Application No: FG/129/21/PL
Site Address: 2 The Poplars Ferring BN12 5QL
Description of works: Demolition of existing semi detached dwelling and erection of new detached dwelling. This site is in CIL Zone 4 and is CIL Liable as new dwelling.

Thank you for your internet representation made on 31st August 2021 which has been recorded as support with the comments as follows:

DRAWING TITLE	PROJECT NO.	DRAWING NO.
Proposed Elevations / Section AA	21001	GE.01
STATUS	DATE	REVISION
PLANNING	07.21	-

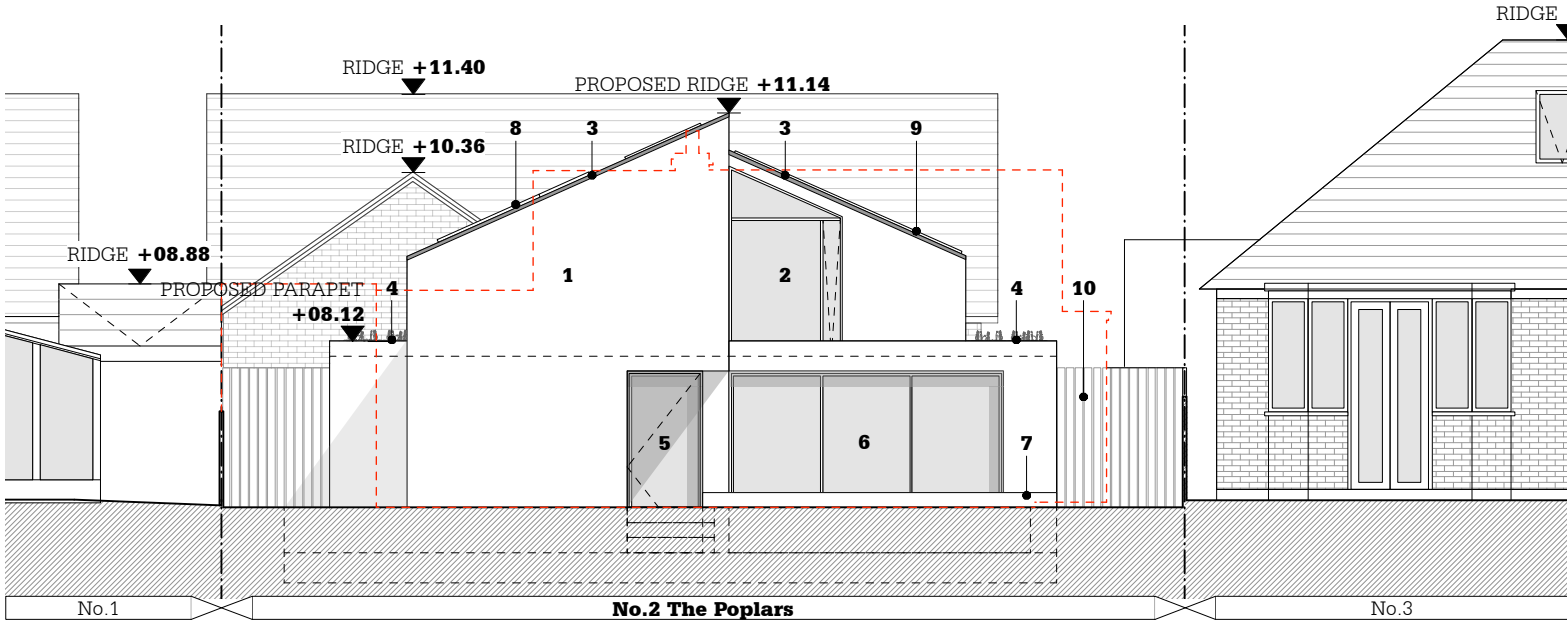
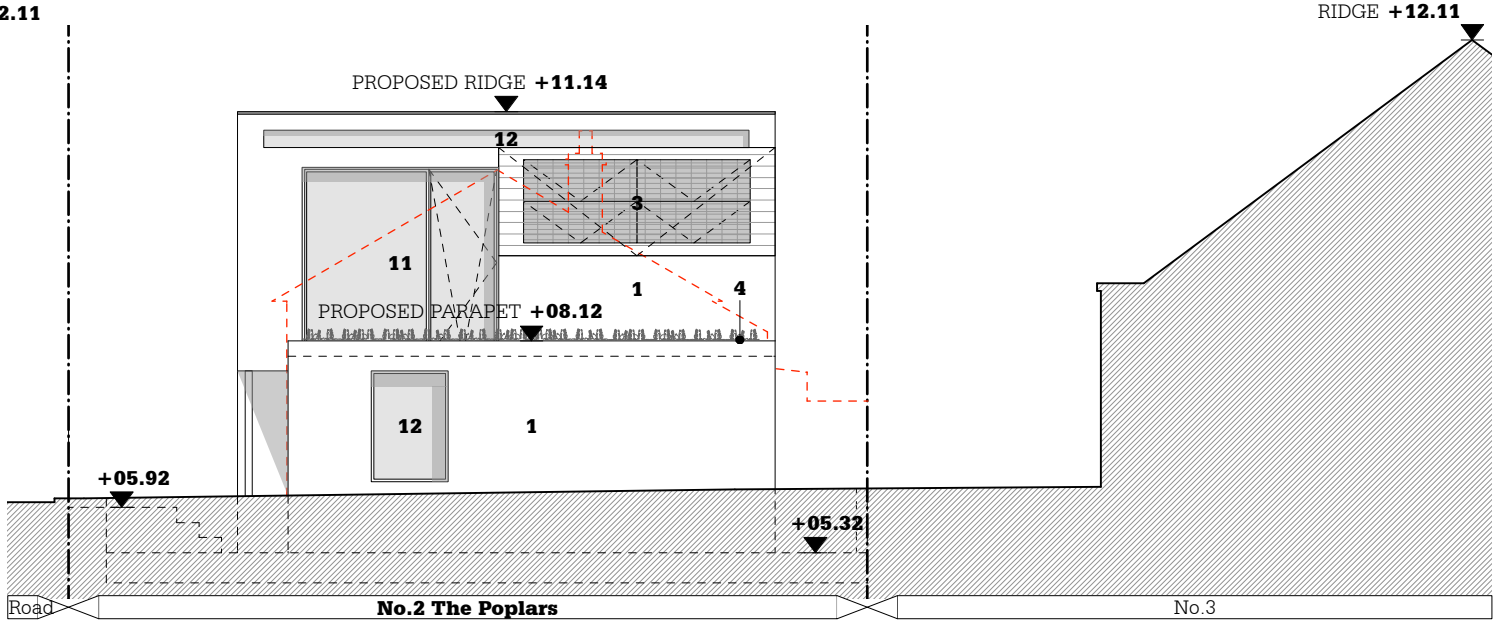
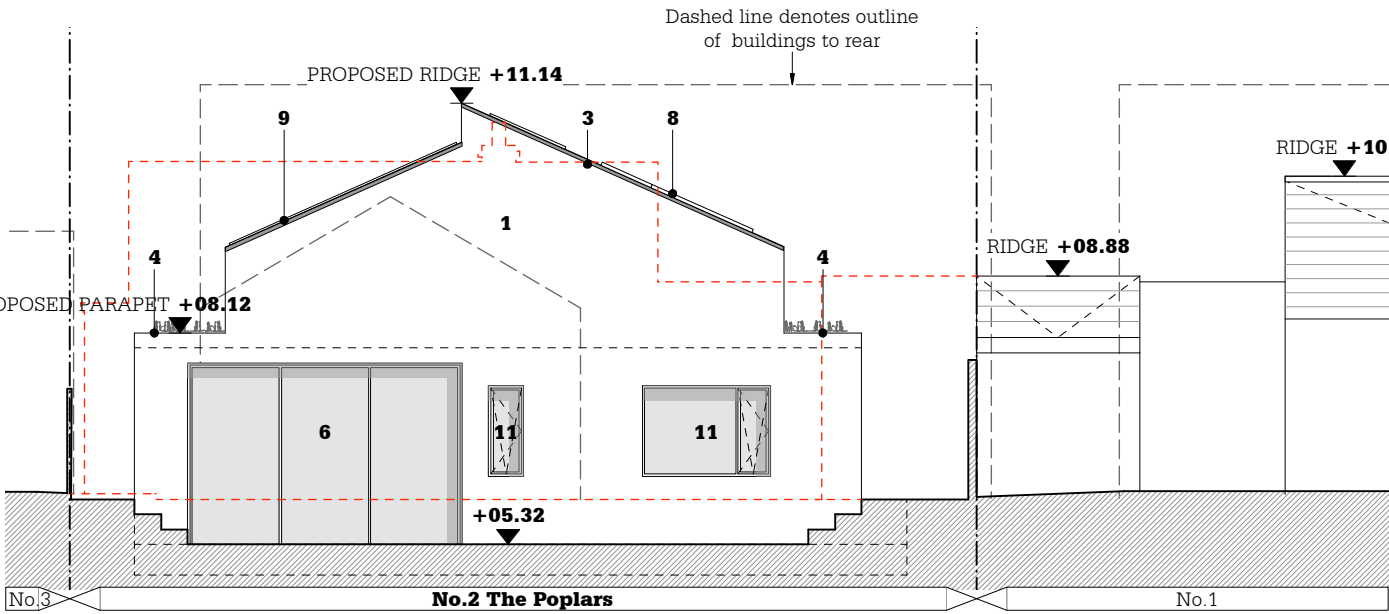
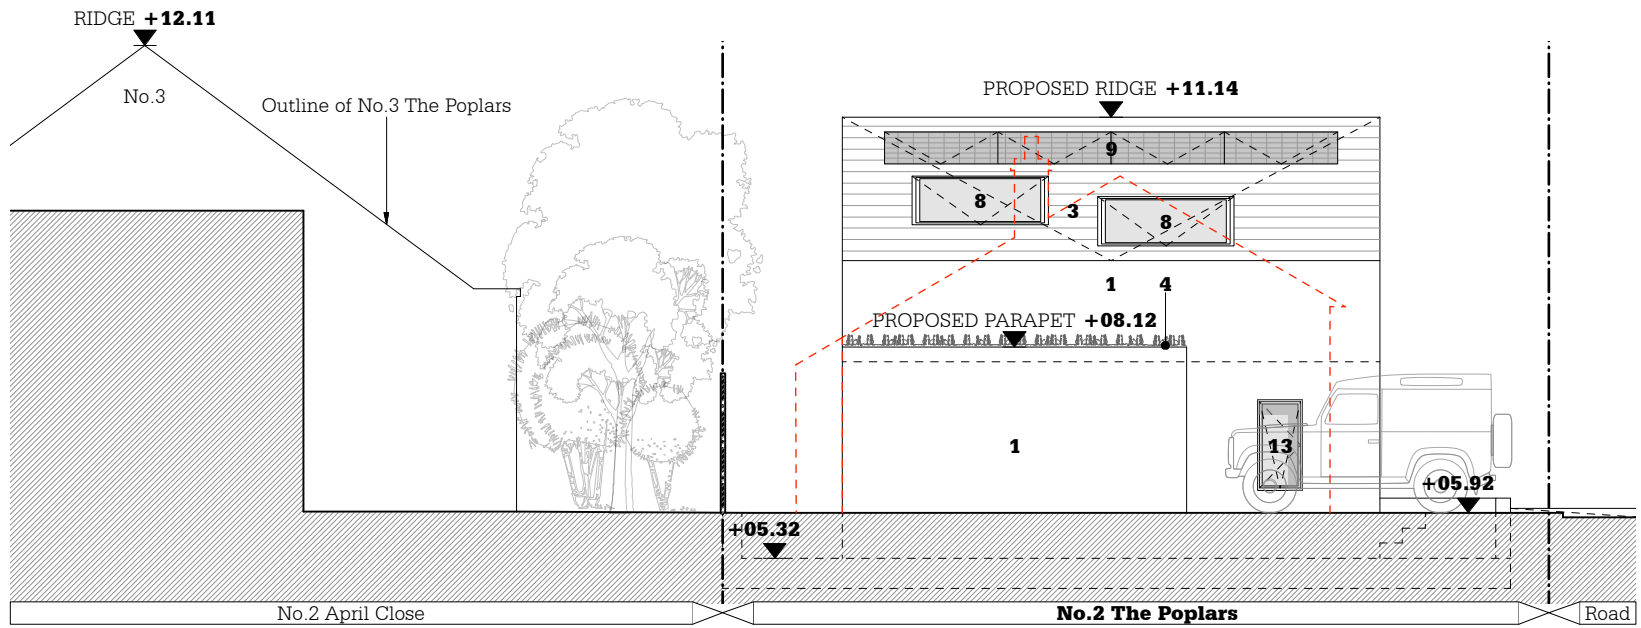
The only concern I have is about the 'planted roof' on the first floor (south side) becoming a balcony now or in the future.

Could you please add a planning condition which would prevent it being used as a balcony for recreational use as this would have a huge detrimental impact on my overall privacy. If planning was granted without a condition I would have no alternative but to object.
